PLANNING APPLICATION CONSULTATION RESPONSE

Application Number:	3/2024/0196
Proposal:	Approval of details reserved by Conditions 9 (surface water sustainable drainage scheme) and 17 (boundary treatment) of planning permission 3/2019/1104.
Location:	Land off Hawthorne Farm Hawthorne Place Clitheroe BB7 2HU

Lead Local Flood Authority Position

Drawing Title
PLOT DRAINAGE

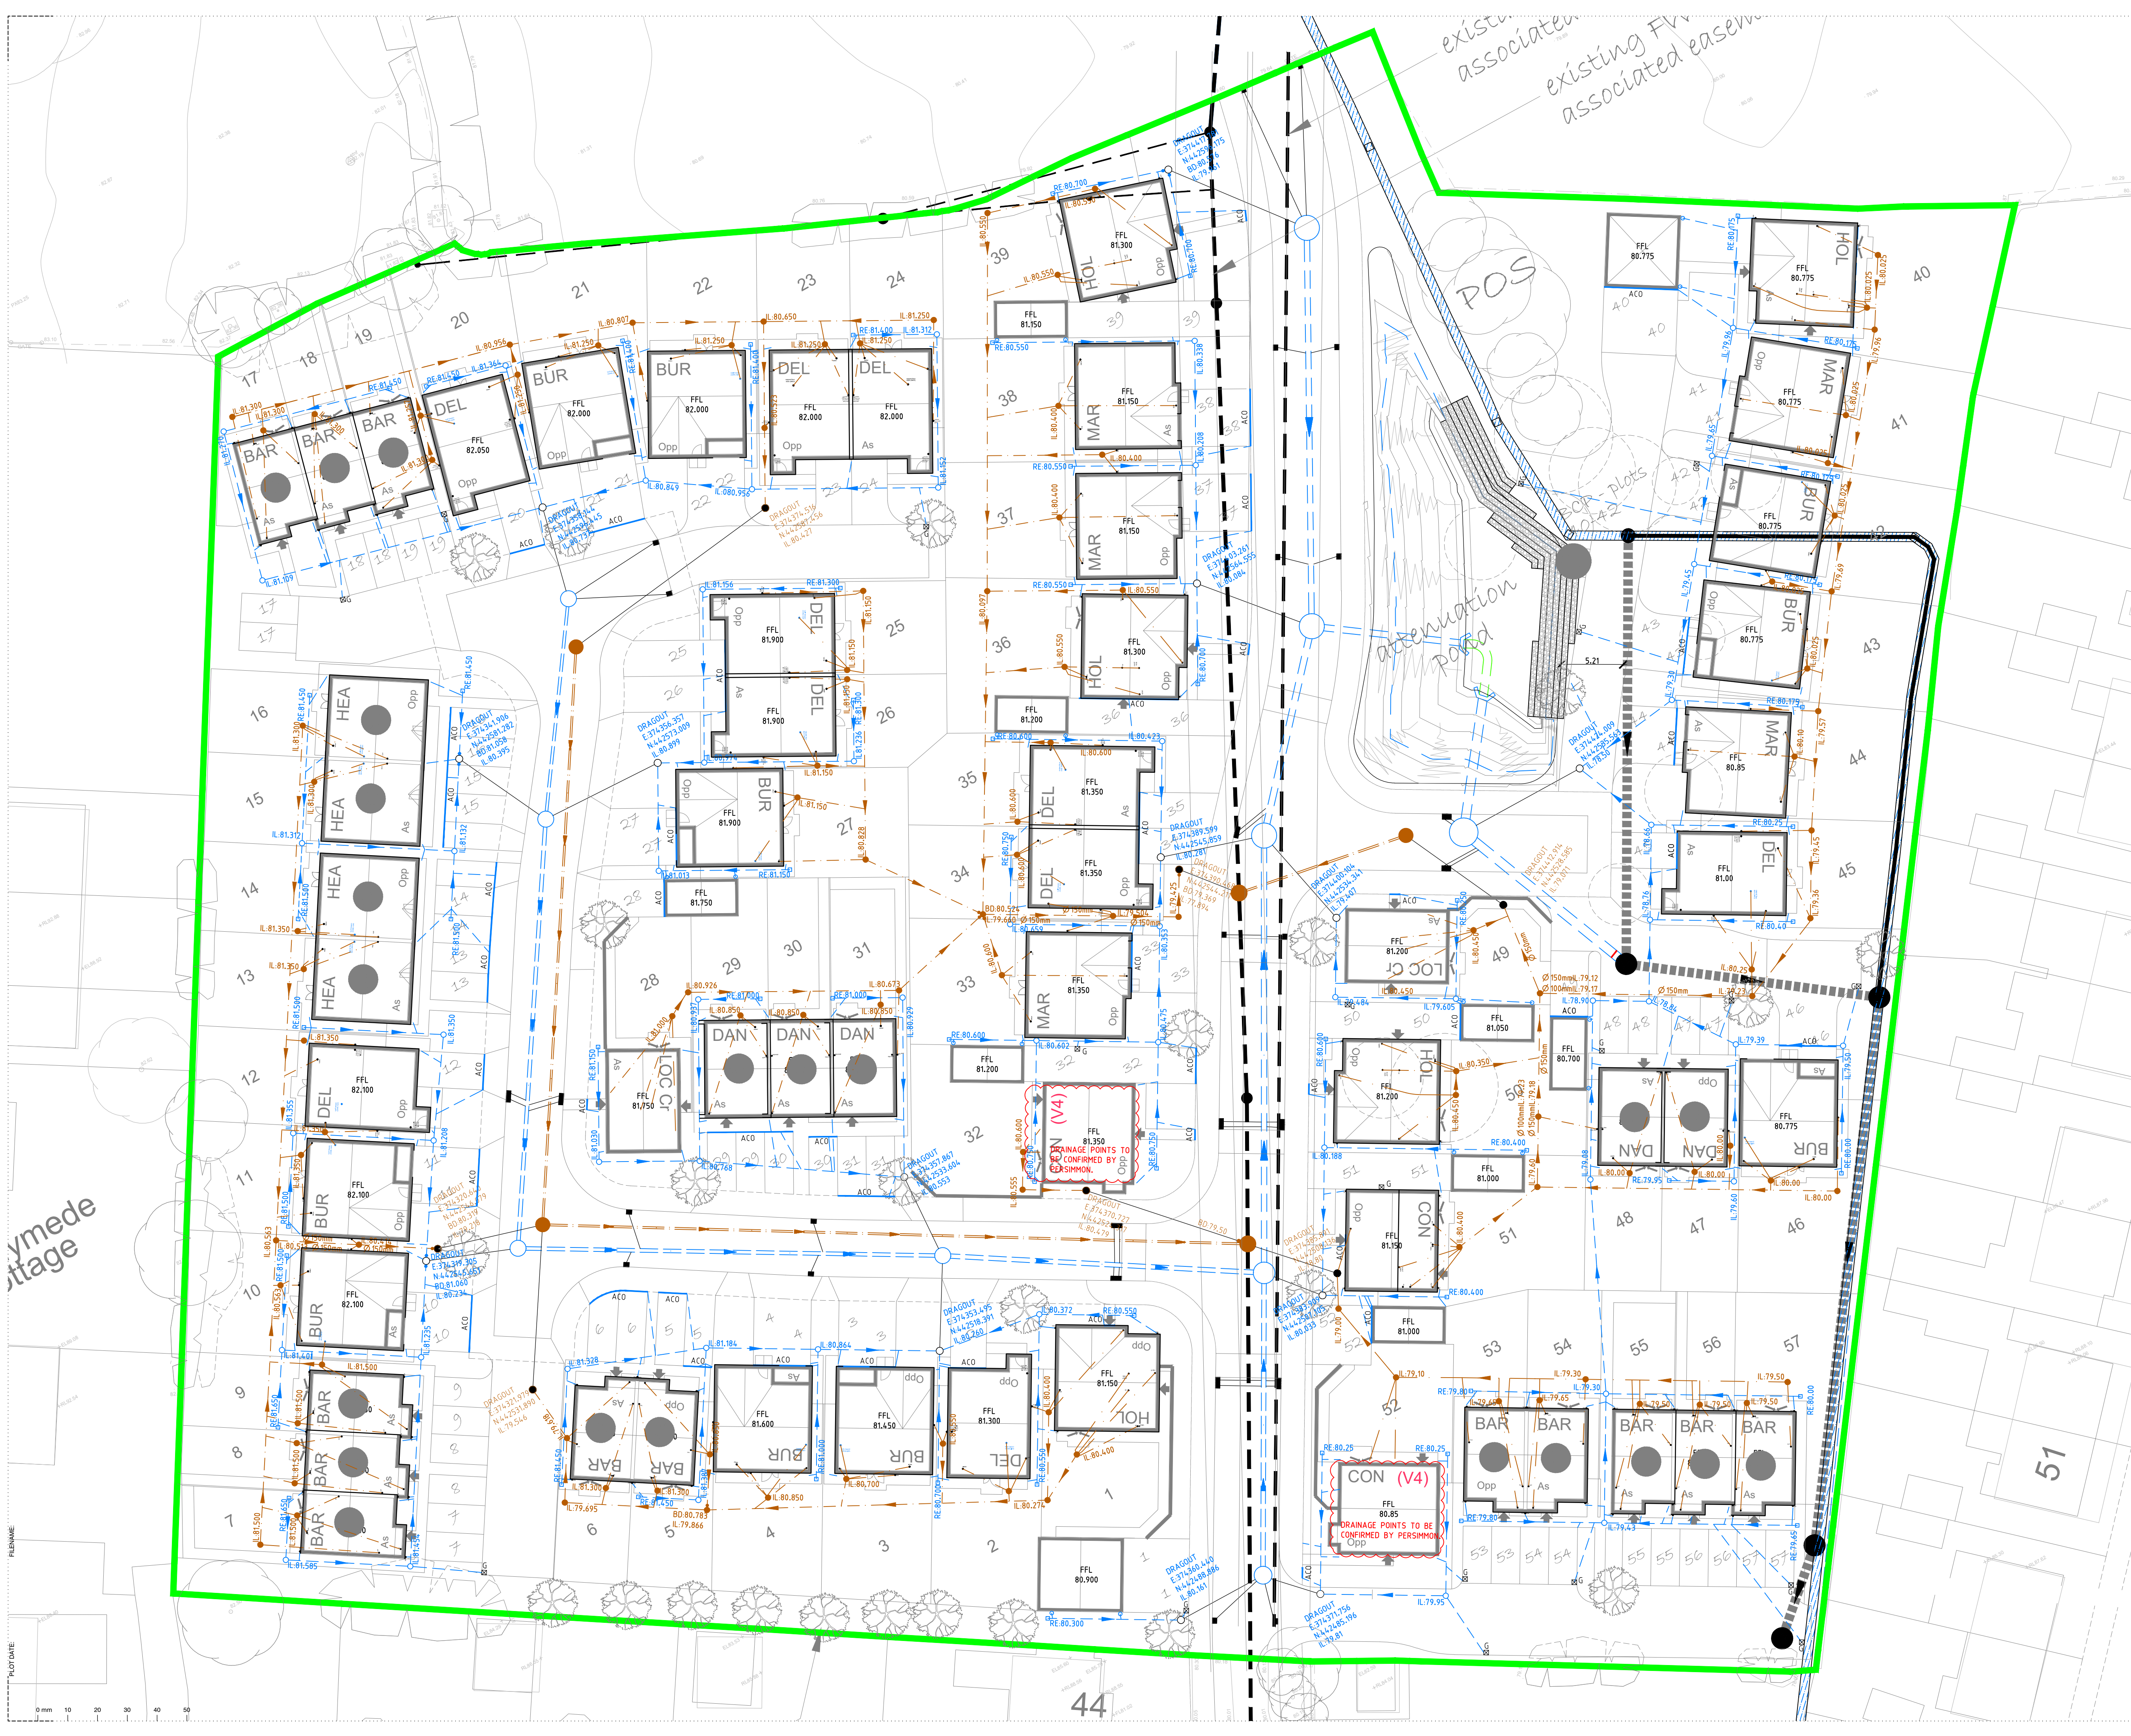
The Lead Local Flood Authority is currently **unable to recommend the discharge of condition 9** on planning decision 3/2019/1104 on the basis of:

- The applicant has failed to provide clear evidence of how the proposed soakaway at the end of the filter drain along the southern boundary has been designed with supporting infiltration rates.
- The applicant should provide further information that demonstrates the future access and maintenance of the proposed filter drain along the southern boundary in regard to the planting of vegetation within the buffer strip.
- The applicant has failed to provide evidence of how the proposed filter drain along the eastern boundary has been designed, in order to demonstrate that the

proposed drain will not increase flood risk or increase the overall discharge rate from the development given its proposal to connect to diverted culverted watercourse.
